Agency Review Comments

Rocky Top, Site Development Plan

PPR1913

LDC Comment Responses 08.30.19
 David V. Hostetler - DVH
 dhostetler@ldc-inc.com
 (719) 528-6133

ROCKY TOP RESOURCES  
SITE DEVELOPMENT PLAN  
PORTION OF THE EAST HALF OF THE NORTHEAST QUARTER OF SECTION 29 AND THE WEST HALF OF SECTION 28, TOWNSHIP 14 SOUTH, RANGE 66 WEST OF THE 6TH P.M., EL PASO COUNTY, COLORADO

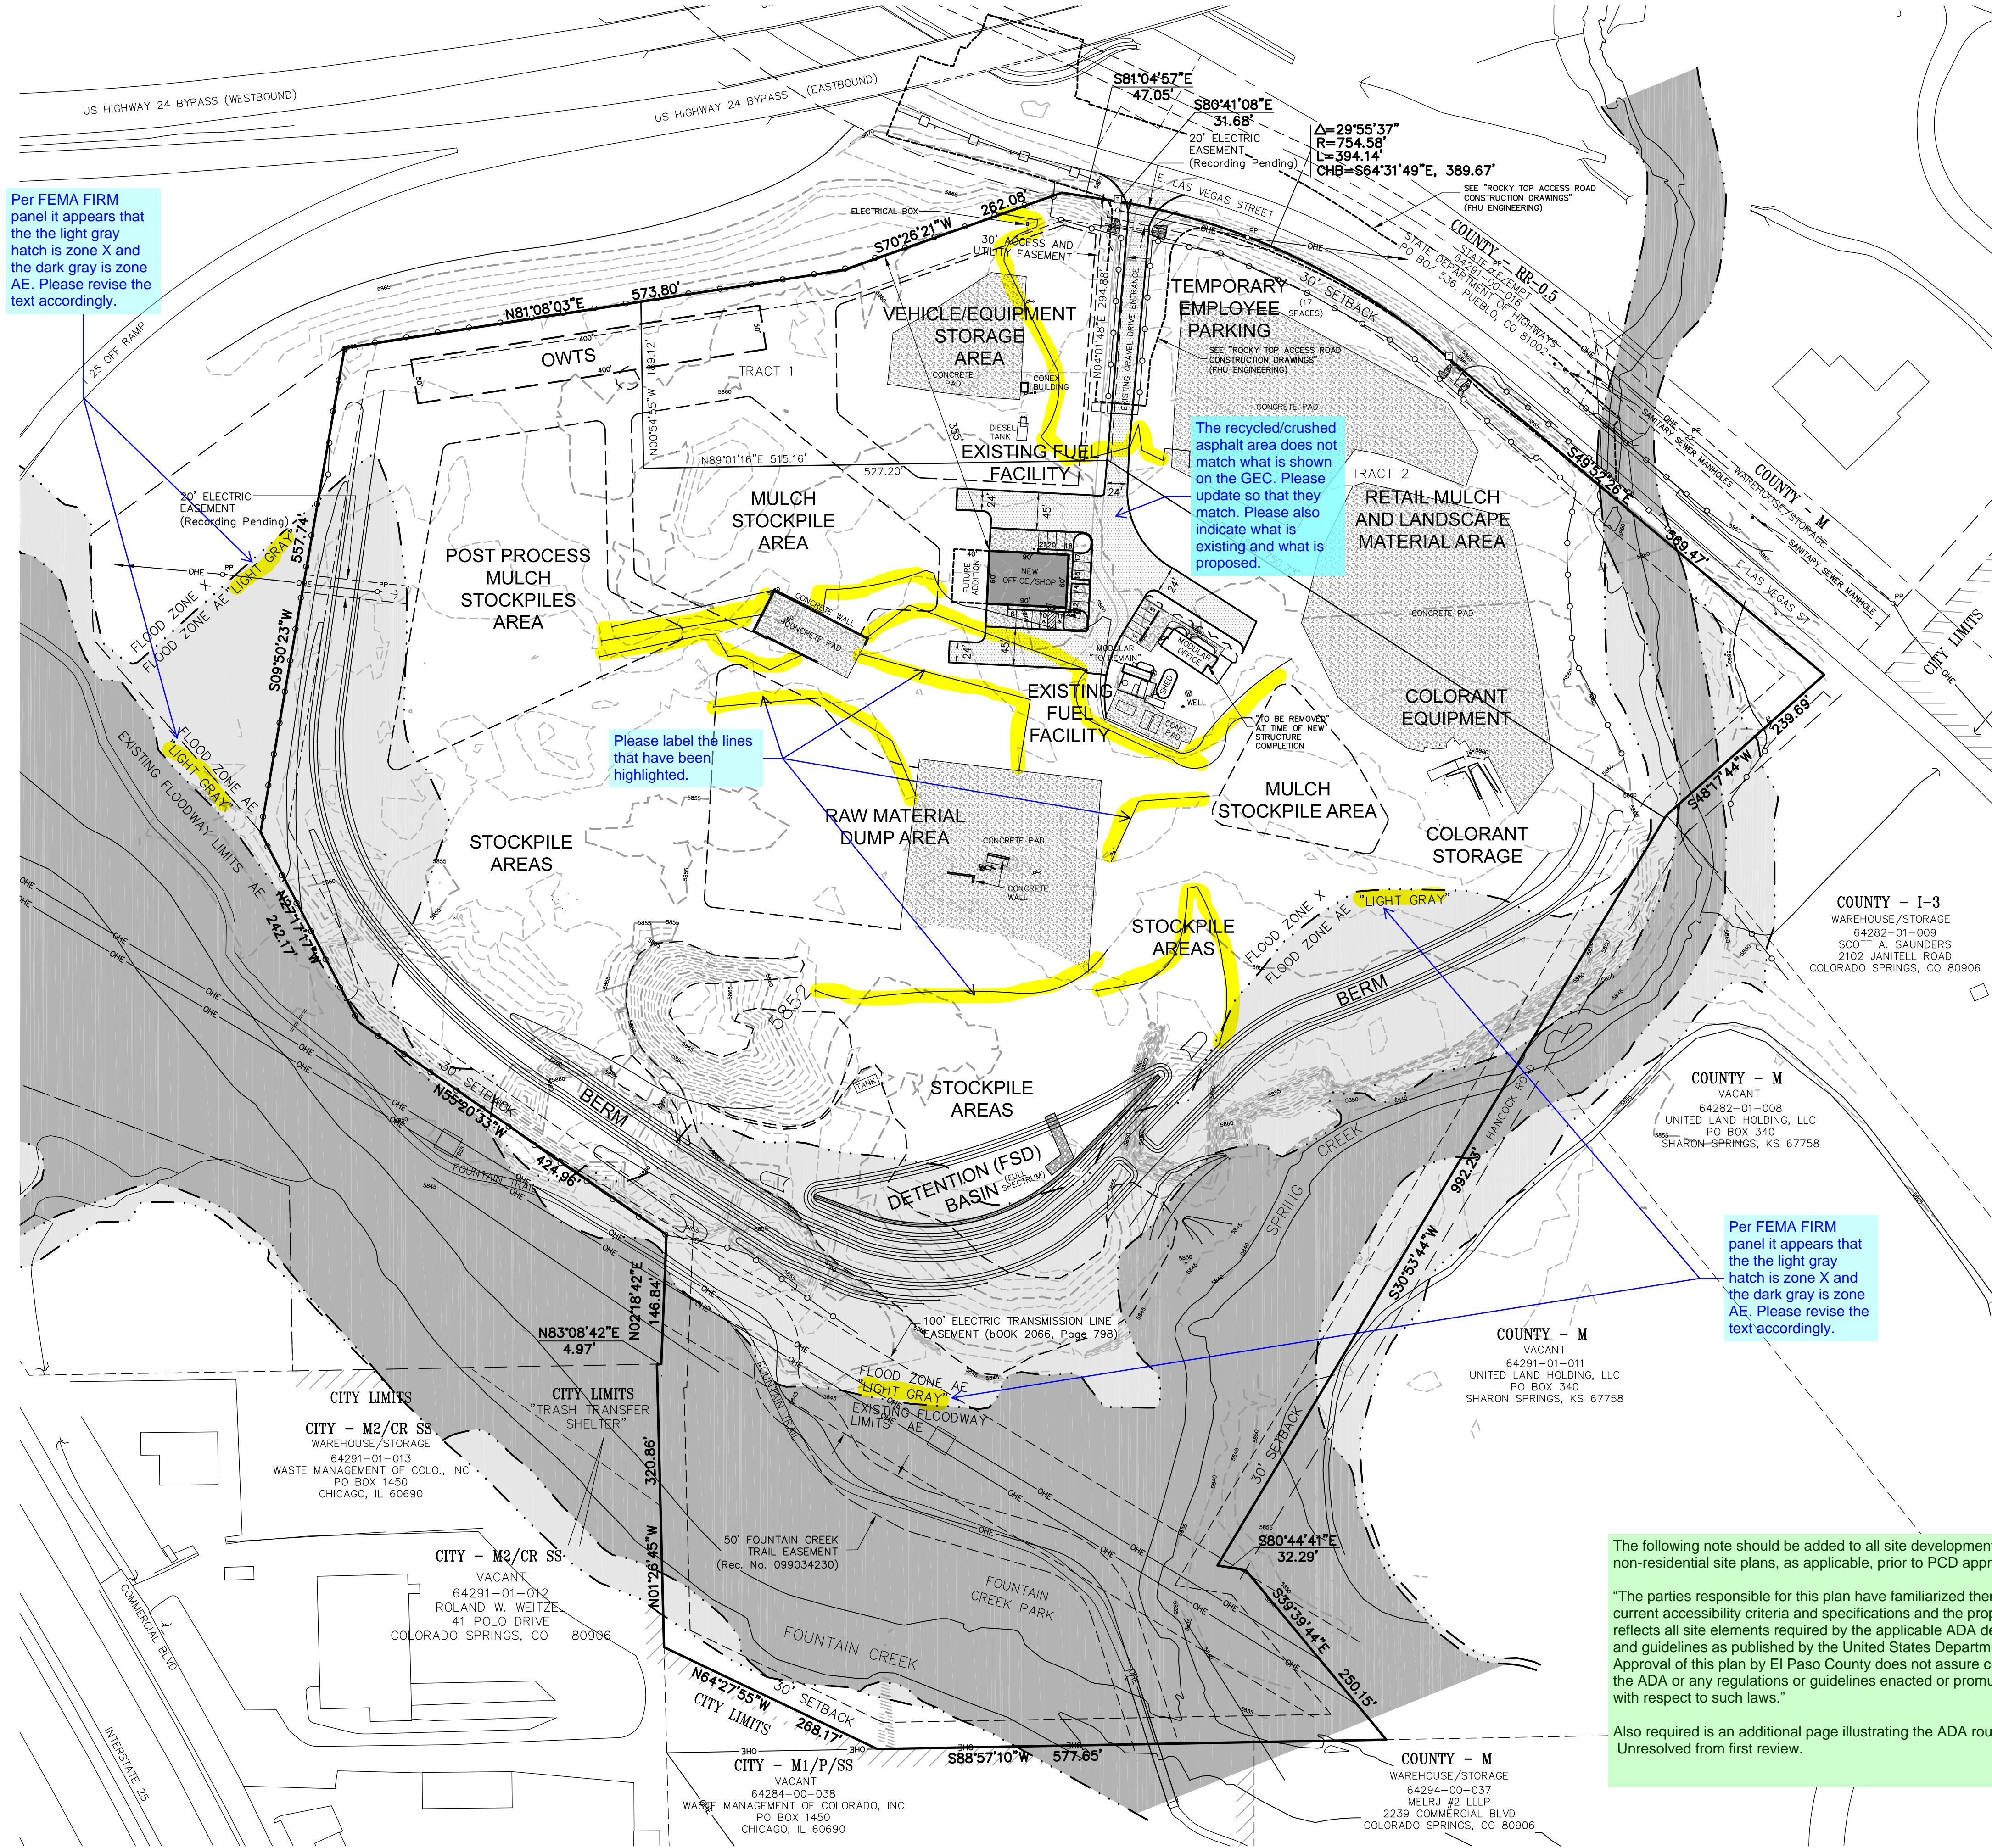
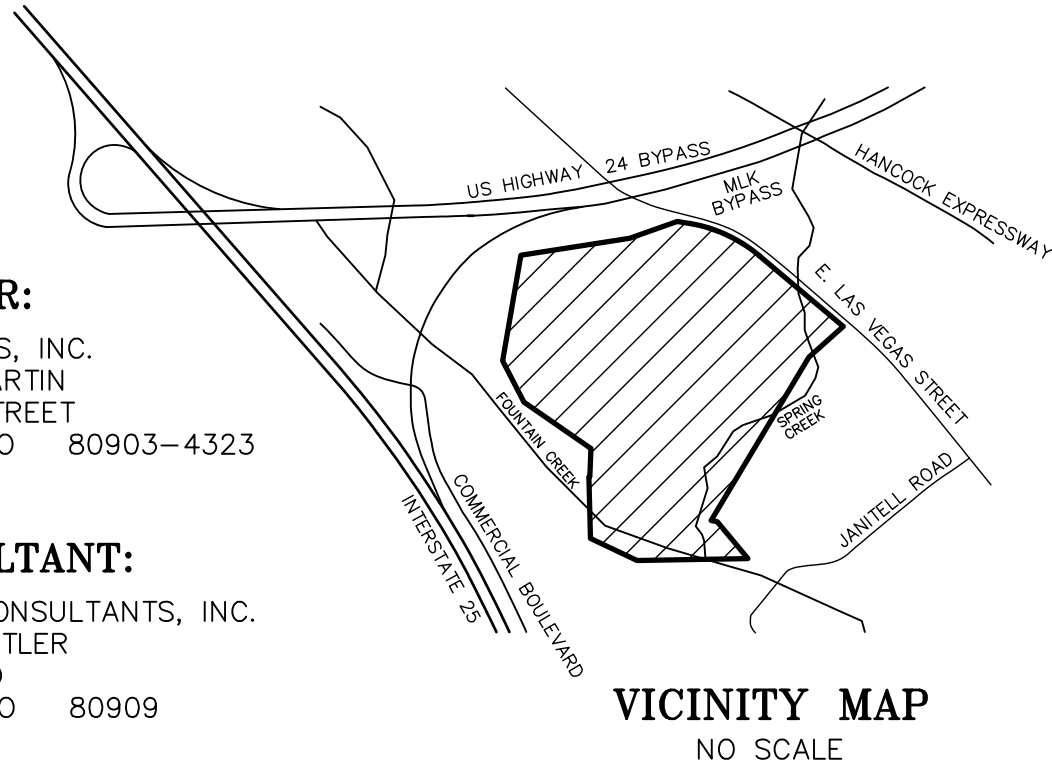
The areas not used are within both the 100-year and the 500-year floodplain. The rest of the site is outside of the 500-year floodplain. Please correct this wording.

Corrected - DVH
